CITY OF PORTLAND

Job ID: 2012-05-4120-NEWCOM

Project Name: 501-509 Warren Ave.; Shed Happens

Shed Happens #2012-474 B-4

GRADING, UTILITY AND LANDSCAPE PLAN

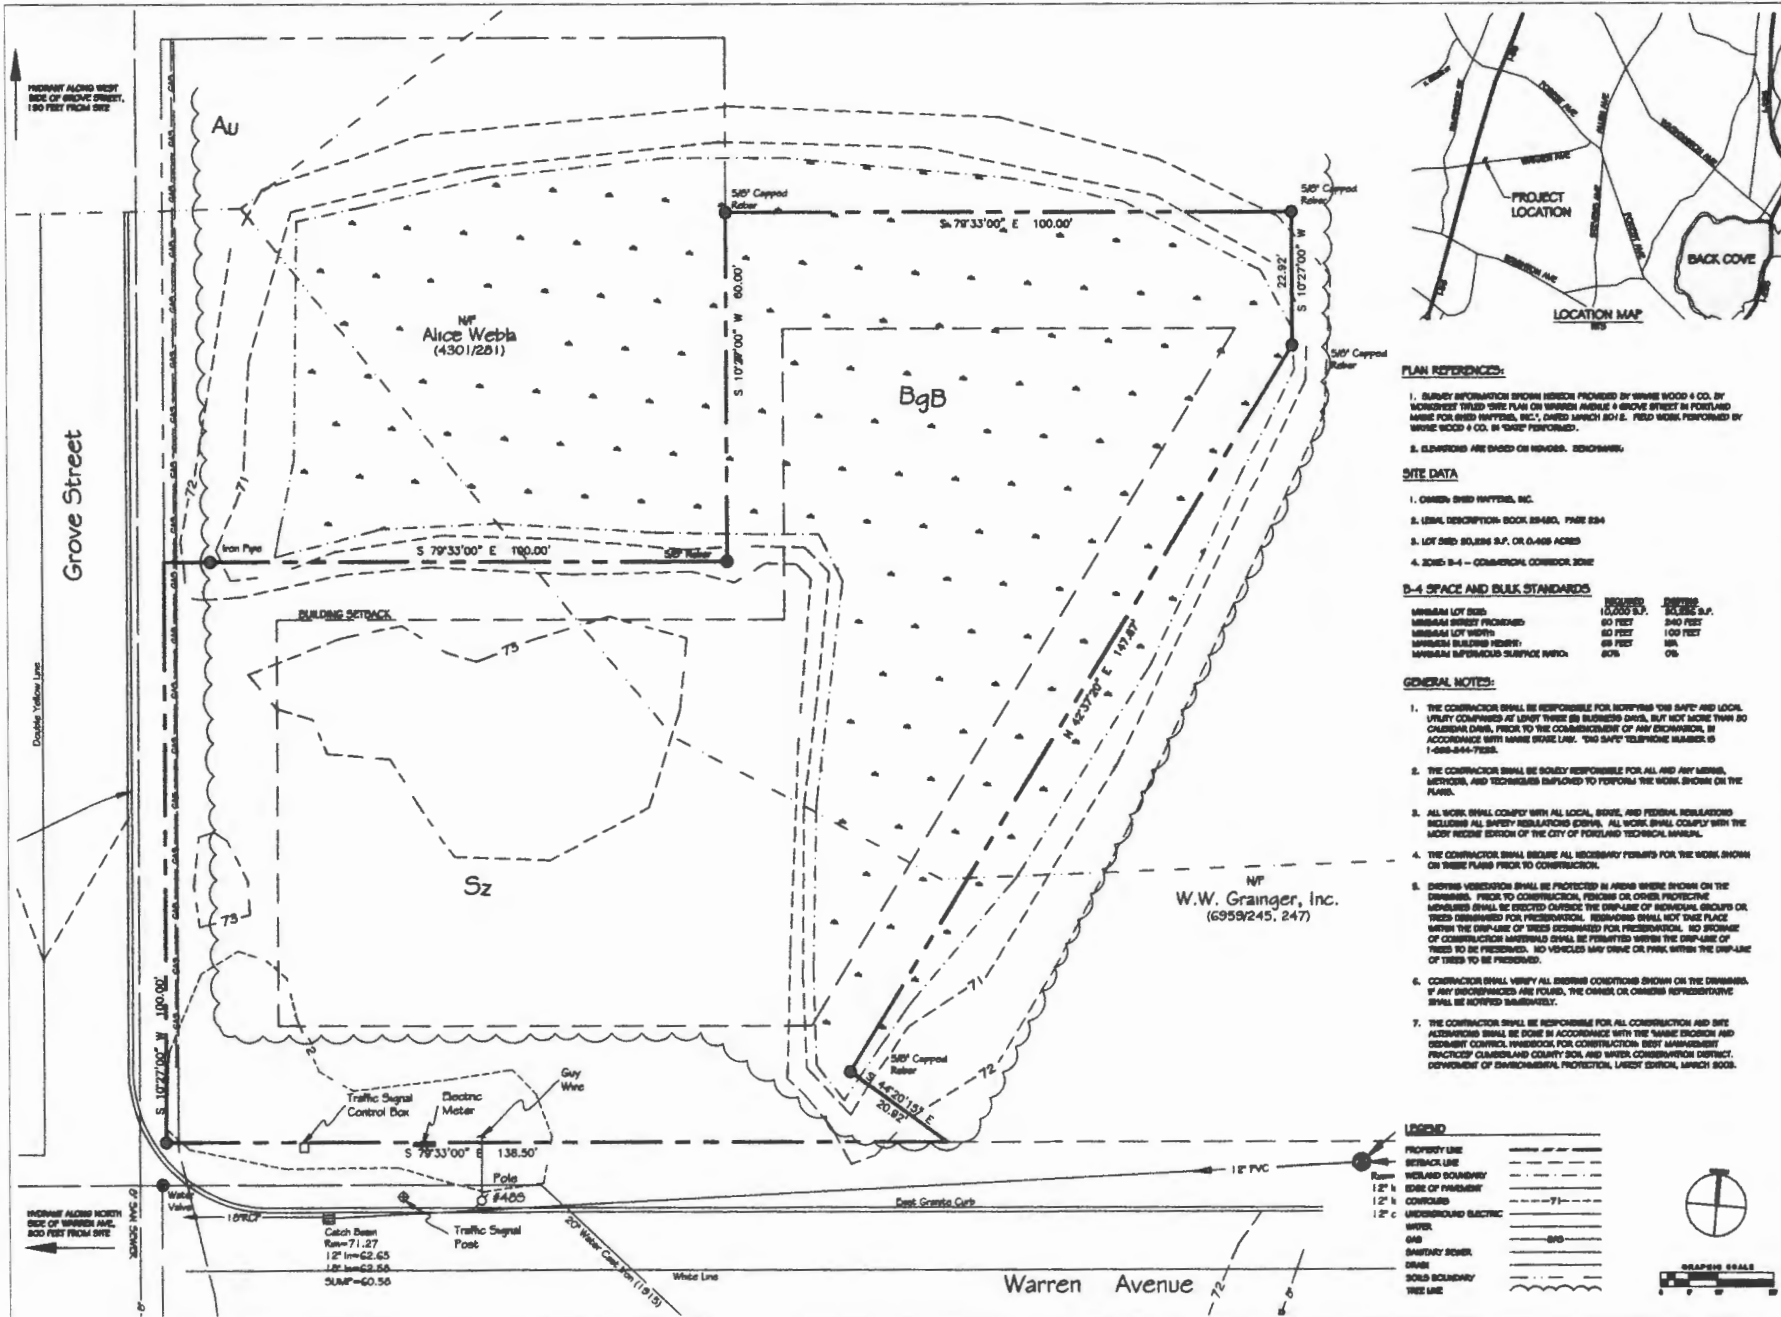
I would also like further information on the impervious surface ratio information. It is my understanding that the impervious surface information only includes paving and gravel area and not any of the surfaces that are covered with structures, such as the retail office and the sheds for sale. Again I would like further clarification on the impervious surface ratio that was submitted.

- c. Retail Office Structure: Sheets L2.0 and L3.0 have been revised to show proposed exterior stairs at the proposed office structure. The park model unit to be used as retail office space shall be placed on a compacted crushed stone pad. The unit will have the tongue, tires and axles removed and the steel frame will set on concrete piers or blocks for leveling. The unit is constructed with hurricane straps which are anchored into the earth to prevent the building from moving in severe weather in accordance with the RPTIA manual and standards.

- b. **Proposed Plantings:** See planting schedule of proposed trees on revised sheet L3.0.
5. **Wetlands:** See attached *Exhibit 1* which shows this area of the proposed wetland disturbance as 4,250 s.f.

4. Overflow Spillway: This spillway has been shown on the grading plan (L3.0). The spillway will activate only on storms above the 100-year interval event and if the primary outfall fail.

LAYOUT PLAN
 Job No. 101 Date: 08/20/2013
 Scale: 1" = 10'-0" Drawing: L2.0
 Designer: TJC
 Checker: WMS

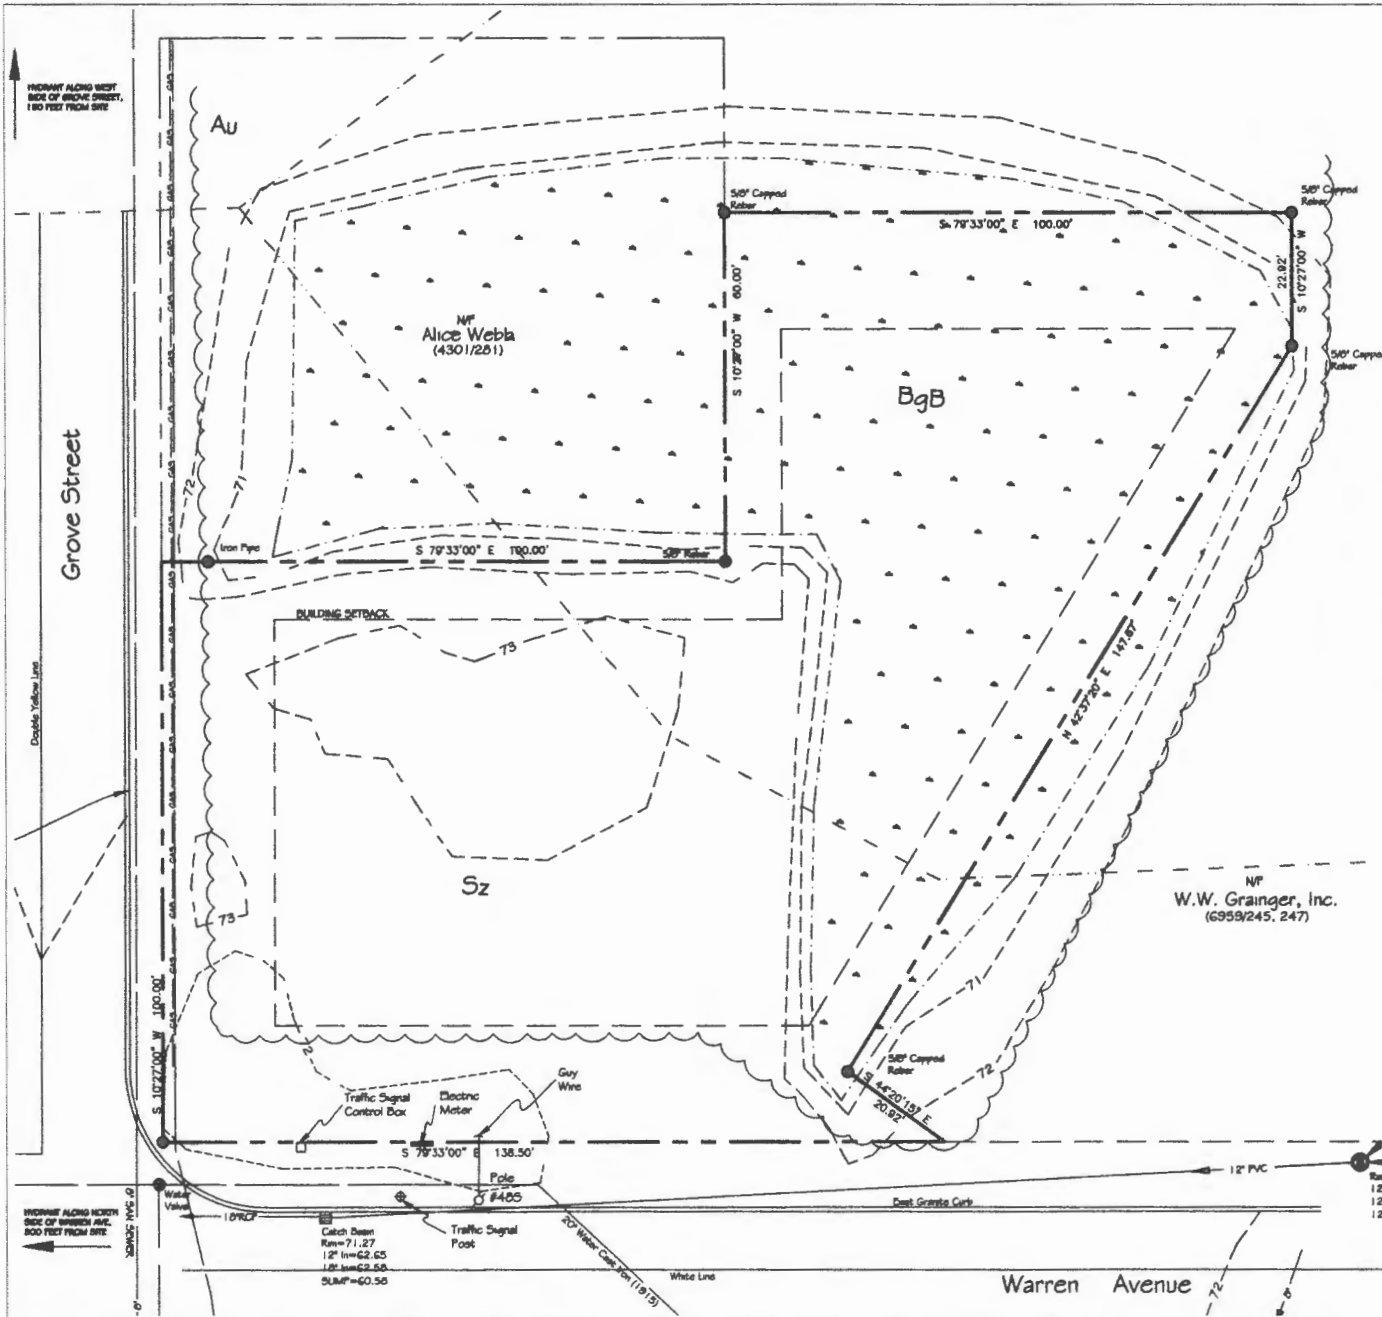
I did see the revised information concerning the impervious surface on L2.0. Because of the wood chip surface, the impervious surface is only at 38.4% which is well under the maximum of 80% required under the zone.

My understanding of the indicated display areas show that the structures that are for sale (the sheds) will be located in the required setbacks – within the denoted display areas. The Zoning Ordinance does not distinguish between temporary or permanent structures. They must meet the setback requirements of the underlying zone, which is the B-4 Zone. The display area that directly abuts Warren Avenue is especially dangerous for site distances for the purposes of traffic. The indication of display areas needs to be revised. I would also like a little more detail for the intended surface of the display areas.

The proposed sign is shown to be located in an area that is not allowed for signage. The applicant does realize that signage requires a separate review and permit. However, I would like the applicant to understand that a sign is also required to meet the requirements of 14-434, Corner Clearance. This section also eliminates any temporary structure in the corner clearance area.

2. Zoning:
 - a. Signage: The proposed sign has been relocated to the southeastern property corner as shown on revised sheet L2.0 –Layout Plan (revision date May 3, 2012.)

- b. Impervious Surface Calculations: The revised impervious calculations are shown on revised sheet L3.0 – Grading and Utility Plan (revision date May 3, 2012). *Actually on L2.0*

8. **Bicycle Parking:** See revised Sheet L2.0 – Layout Plan for the location of the proposed bicycle parking.
